KITTITAS COUNTY

MEMORANDUM

TO: All Staff
FROM: Public Works Plan Review Team
DATE: March 26, 2024
SUBJECT: SP-24-00002 Carr

CARR SHORT PLAT  
 PART OF SECTION 35, T. 17 N., R. 19 E., W.M.  
 KITTITAS COUNTY, WASHINGTON

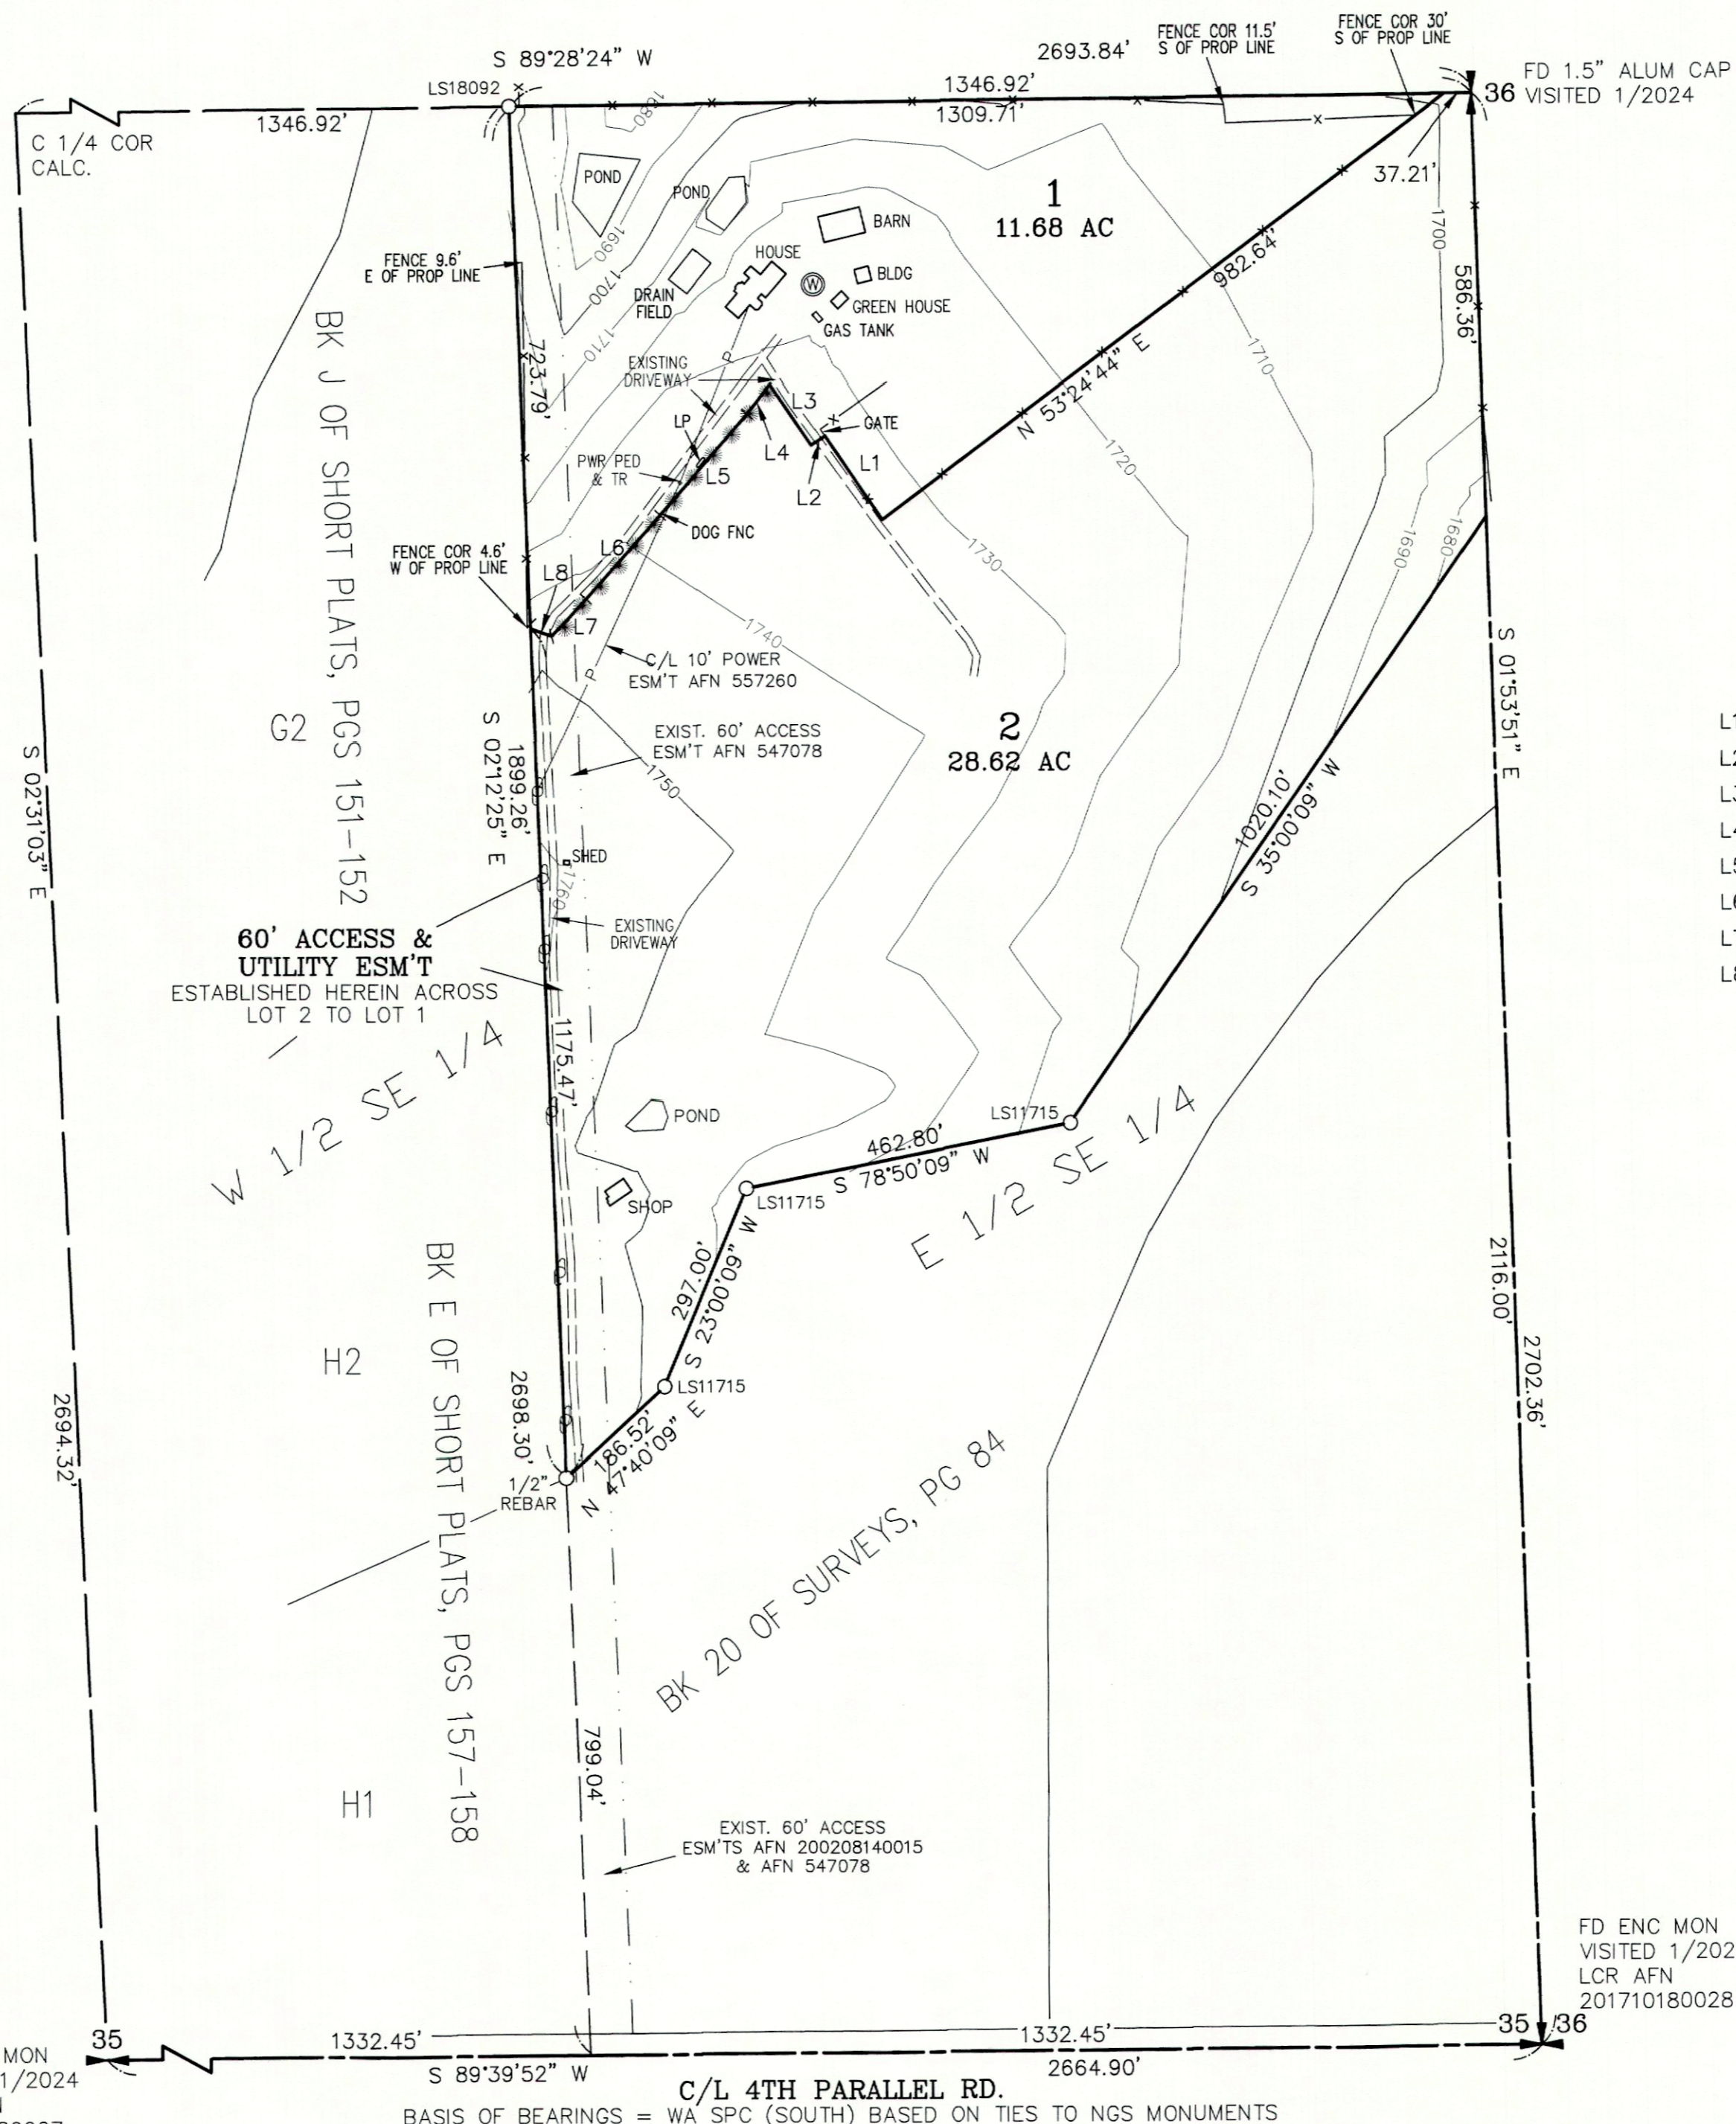
<p>ENGINEERING</p>	<p>Except as exempted in Section KCC 14.05.060, no grading or filling upon a site involving more than one hundred (100) cubic yards shall be performed without a grading permit from the County Engineer or Public Works designee (KCC 14.05.050). An application for grading in excess of five hundred (500) cubic yards shall be accompanied by an engineered grading plan (KCC 14.05.080). (CC)</p>
<p>SURVEY</p>	<ol style="list-style-type: none"> 1. Ownership and width needs identified on 4th Parallel Rd. <p>Of Note</p> <ol style="list-style-type: none"> 1. Title needed by final 2. Boundary line will need to be staked in the field and corners shown on the face of the map.

<p>3. Lot closures will need to be provided. The original parcel shows 40.93 acres on Assessor's map, new lots total 40.3 acres.</p> <p>4. Existing driveway width and surface type to be labeled. (KAH)</p>
TRANSPORTATION CONCURRENCY	No transportation concurrency requirements for this project (KAH)
FLOOD	Parcel # 010433 is not located in a FEMA identified special flood hazard area (100-year floodplain). A floodplain development permit is not required. (SC)
WATER MITIGATION/ METERING	<p>The following comments outline the requirements for legal availability of water and metering for the proposed short plat:</p> <p>The applicant must provide legal water availability for all new uses on the proposed lots of this project, which can be provided through mitigation certificates. Prior to final plat approval and recording, the following conditions shall be met:</p> <p>In accordance with KCC Chapter 13.35.027, the applicant shall provide one of the following documents before final plat approval:</p> <ol style="list-style-type: none"> 1. A letter from a water purveyor stating that the purveyor has adequate water rights and will provide the necessary water for the new use; 2. An adequate water right for the proposed new use; or 3. A certificate of water budget neutrality from the Department of Ecology or other adequate interest in water rights from a water bank. <p>All applicants for land divisions shall also submit information on "proximate parcels" held in "common ownership" as those terms are defined in WAC 173-539A-030 and otherwise demonstrate how the proposed new use will not violate RCW 90.44.050 as currently existing or hereafter amended.</p> <p>Failure to obtain mitigation before commencement of an activity requiring mitigation shall be a code violation subject to enforcement under Title 18 KCC.</p> <p>Final Plat Notes</p> <p>The following notes shall be placed on the face of the plat:</p> <p>C-1 "Metering is required for all new uses of domestic water for residential well connections and usage must be recorded in a manner consistent with Kittitas County Code Chapter 13.35.027 and Ecology regulations."</p> <p>C-2 "The approval of this division of land provides no guarantee that use of water under the ground water exemption (RCW 90.44.050) for this plat or any portion thereof will not be subject to curtailment by the Department of Ecology or a court of law." (SC)</p>
